STAFF REPORT

Canyon River Ranch Conditional Use Permit, CU-12-00002

TO: Kittitas County Hearing Examiner
FROM: Kittitas County Community Development Services Staff
RE: Canyon River Ranch Conditional Use Permit (CU-12-00002)
DATE: June 13, 2013 (Hearing Date)

Canyon River Ranch II
Proposed Conditional Use Site Plan

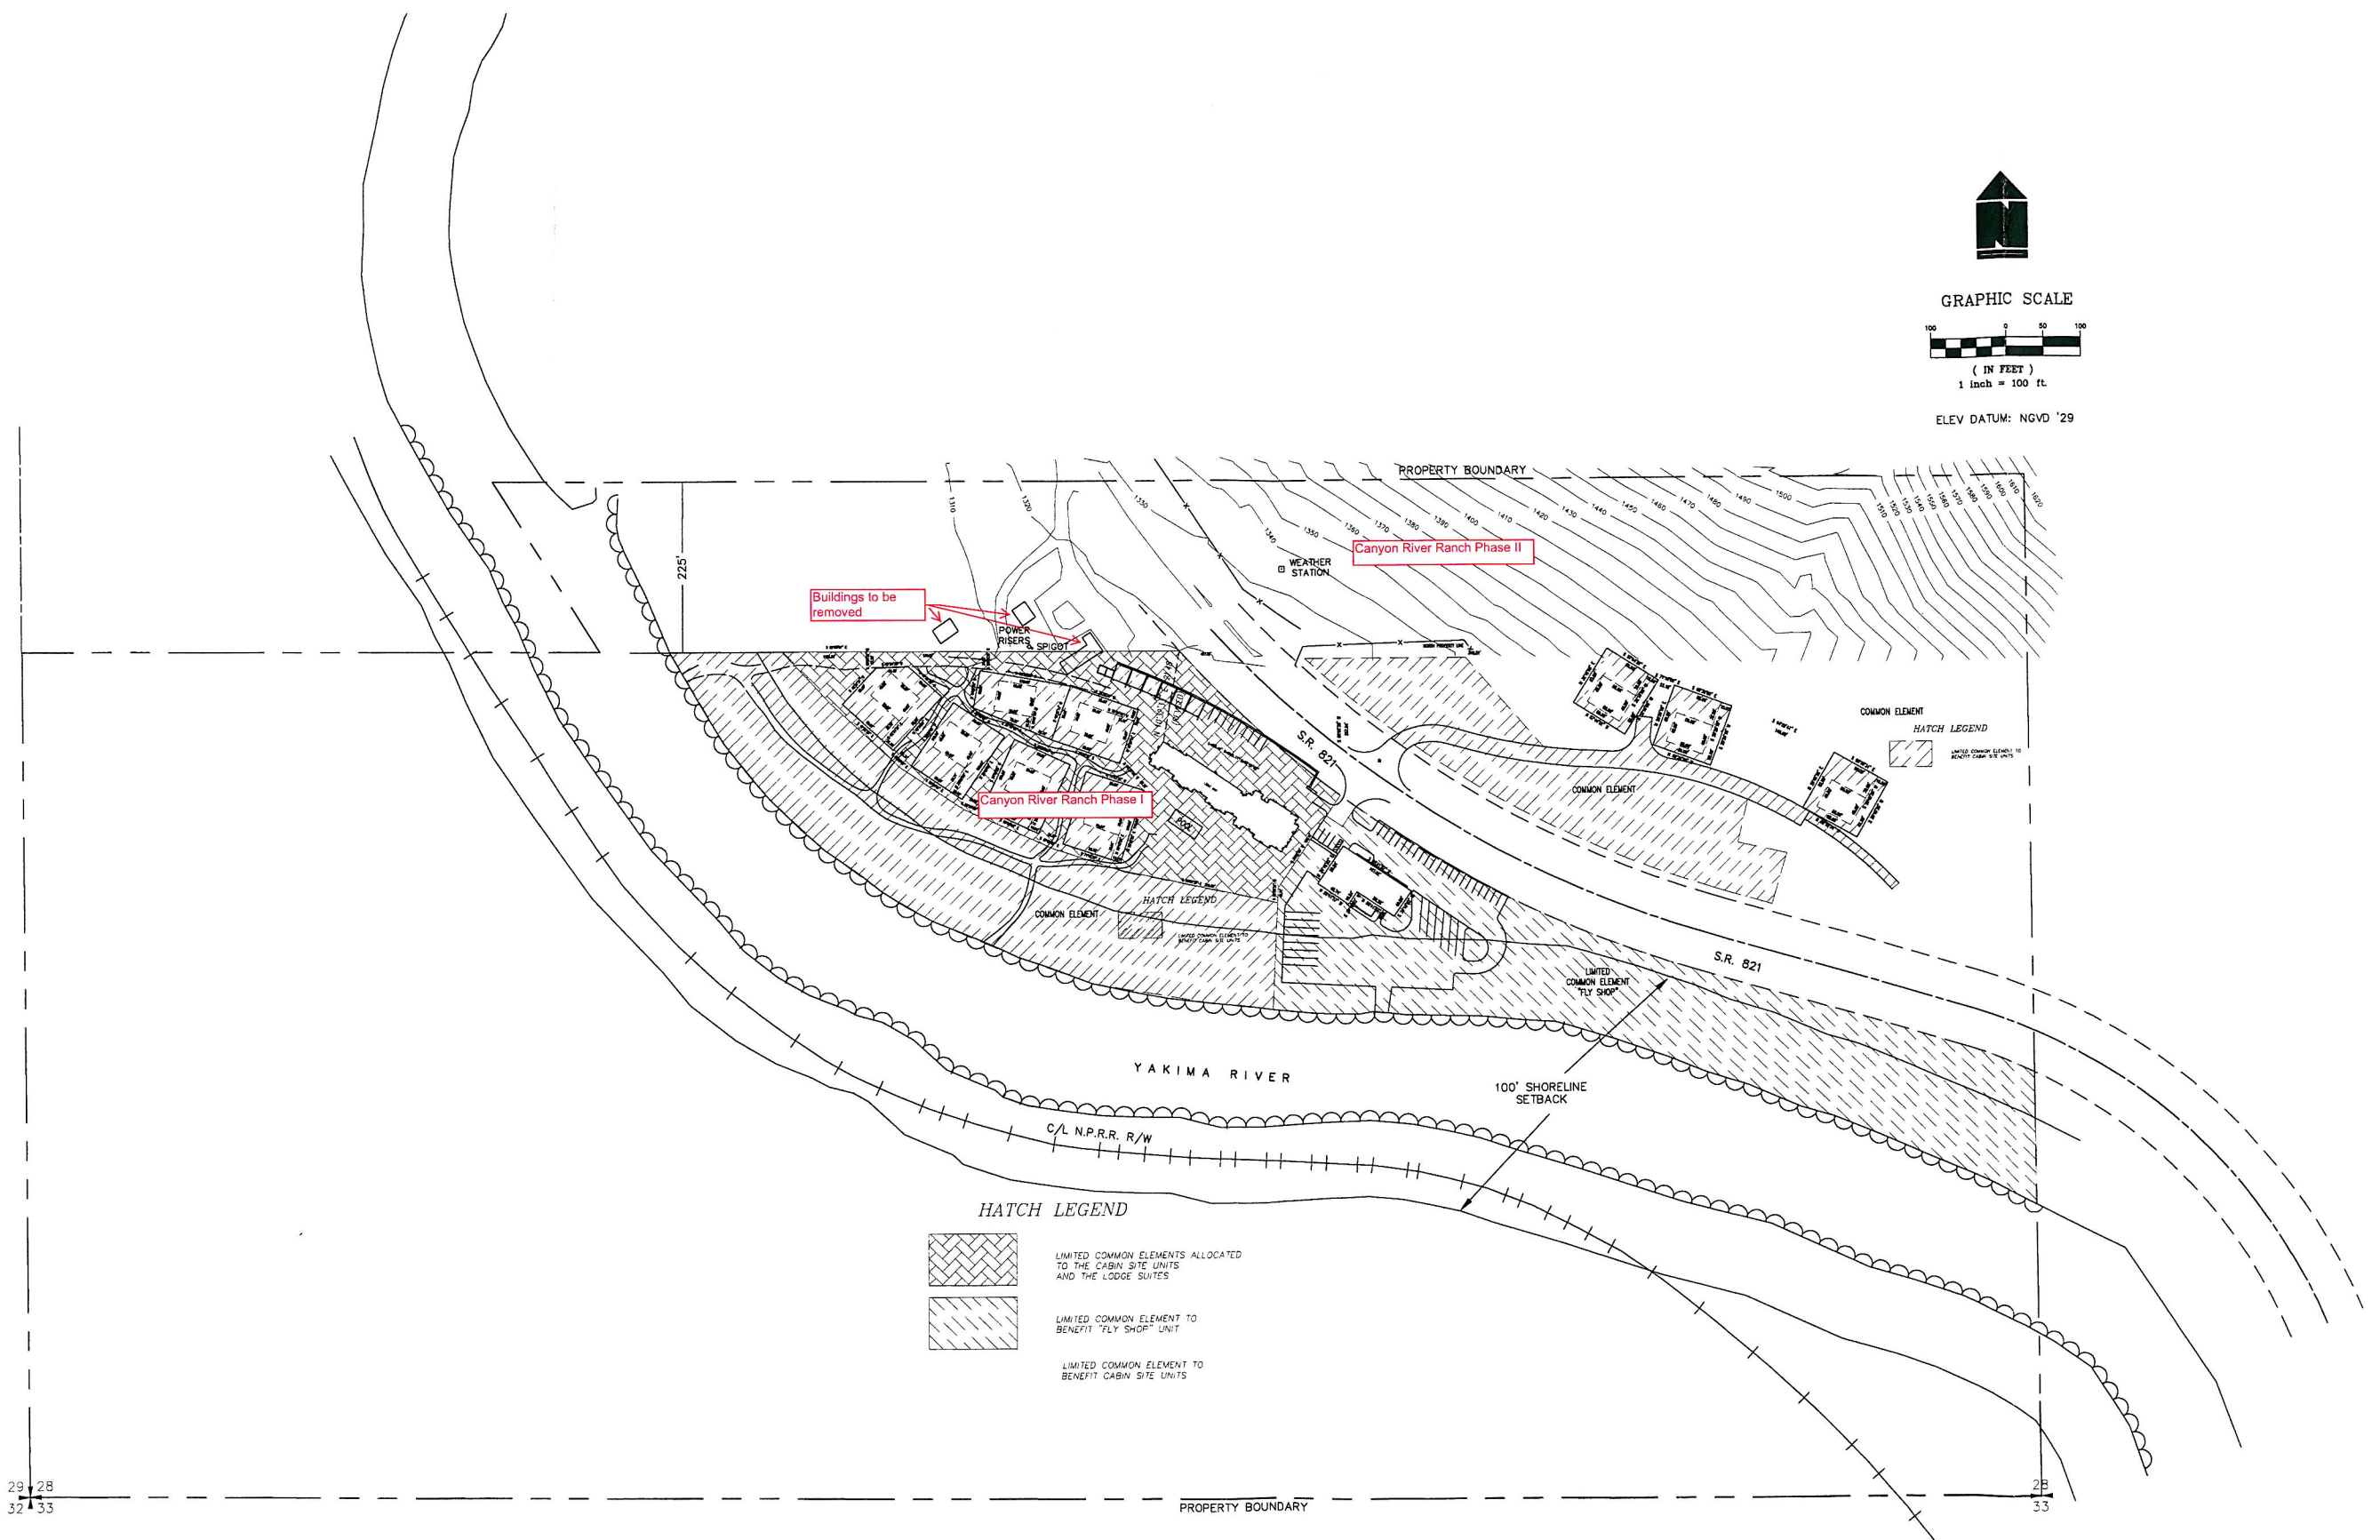
17. The proposed project is located along the Yakima River. The applicant has not supplied a larger scaled drawing documenting the ordinary high water mark (OHWM) in relationship to the planned building and grading areas.

19. Because the request for the expansion of the development does not include any work within the shoreline regulated by the Shoreline Master Program, all development proposed will be shown on scaled 1" = 50' final site plan documenting the Ordinary High Water Mark (OHWM) along the Yakima River in relation to planned building and grading areas and existing and proposed utilities. Floodways and associated wetlands are considered part of that shoreline area, and any indication of floodways or wetlands upon the property as determined by the Department of Ecology, and which are associated with the Yakima River will require floodway assessment and/or wetland analysis prior to any construction on the site.
